From: [Grant, David](#)
To: [_planningadvice](#)
Subject: FW: Poplar Farm Estates H03-0681-21
Date: 07 December 2021 11:39:55
Attachments: [image001.png](#)
[image003.png](#)
[We sent you safe versions of your files.msg](#)
[SW21-134-The Plough, Soakaway with 2.0 FOS.pdf](#)

Job Details SW21-134 - Residential Development, The Plough, Deeping st Nic.

Title Soakaway sizing calculation

Soakaway Trench Detail

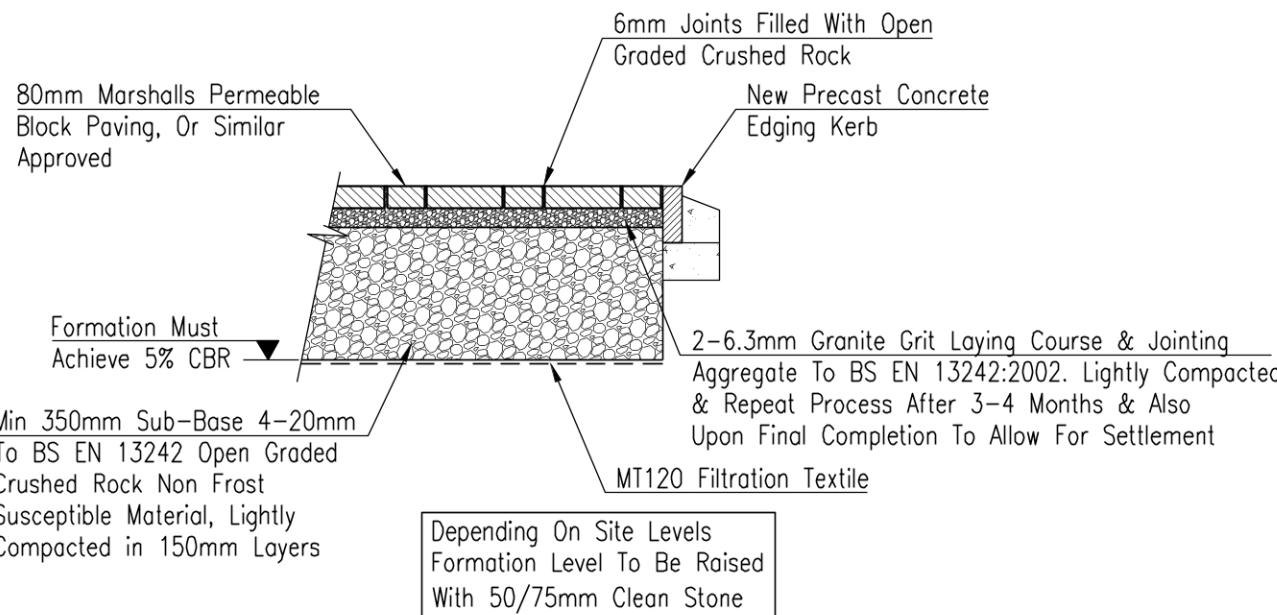
In this scenario it is considered to be appropriate to undertake 3 successive fills. The second and third fills would be slower than the first so infiltration may not actually be a viable method.

The submitted soakaway tests appear to be based upon just one fill of the trial hole whereas the BRE Digest 365 recommendation is that there should be three successive fills, to simulate longer periods of rainfall.

Also, the infiltration rates that have been calculated are very low.

Whilst BRE 365 does recommend 3 test pit refills, this is generally impractical in the south Lincs and fenland area, due to the average infiltration rates being in the region of 5×10^{-6} . We have been undertaking test in this manner in this area for many years and this test manner has always been accepted as reasonable in the past. We have never encountered issues with Garden soakaways sized using infiltration rates calculated using this test manner.

This site has yielded a test result in line with what we would anticipate being an average for this area.

Whilst the infiltration rates achieved were very low, the underlying strata on the site were of a granular nature and Ground water has not been encountered during any investigations or explorations on the site.

Should it be necessary to allay any concerns we can increase the garden soakaway sizes to provide an additional layer of robustness and factor of safety. I have attached a calculation using an infiltration rate with a factor of safety of 2 and a 5x3 crate soakaway.

Typical Permeable Private Roadway Detail

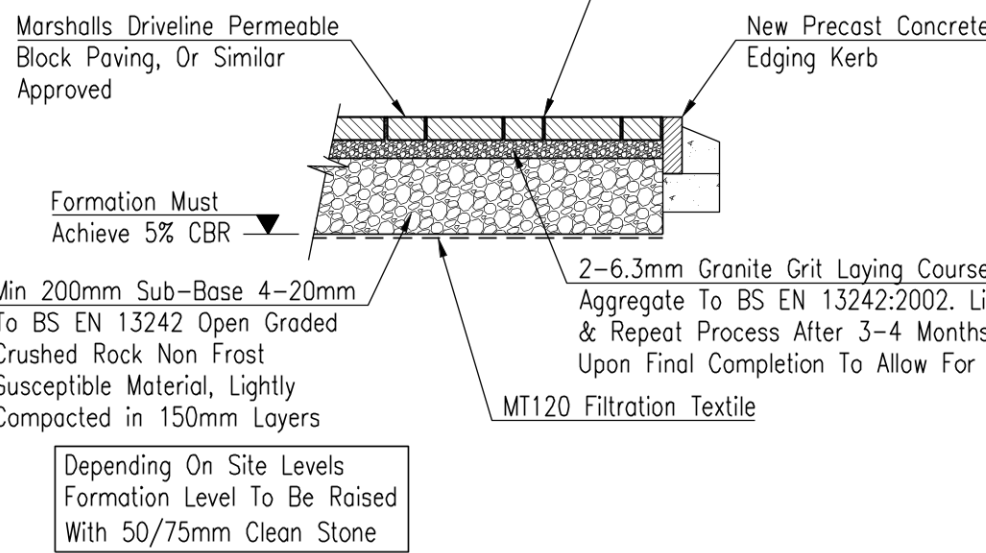
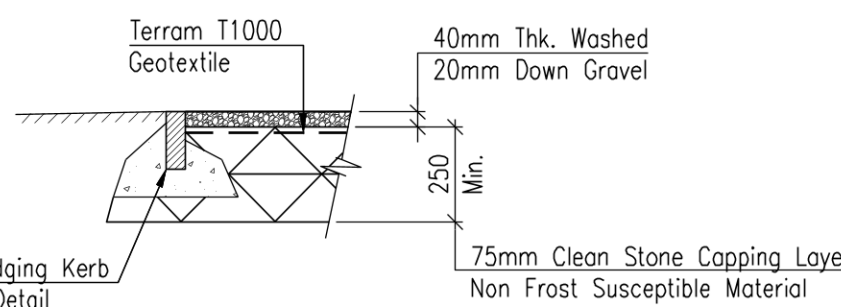
Application the drainage details are for the Local Planning Authority to consider.
I suggest that in terms of the specification and grading of the material to be used for the sub-base of the permeable roads, the appointed contractor would be advised to have regard to the information provided in the LCC Development Road Specification;

A Type 3 material should be used.

The sub-base specified is in line with the Interpave design guidance for concrete block paviour permeable systems, and is a stone specification which will provide good drainage characteristics and the ability store water in its voids. It is similar in nature to a type 3 specification.

The interpave design guidance recommends a min. of 140mm depth of this sub-base material for a surface on a site with this type of low infiltration rate.

As can be seen we have specified a min of 350mm build up under the drive and 200mm under parking spaces which will provided additional storage over and above that required by the 1 in 100 year storm plus climate change.
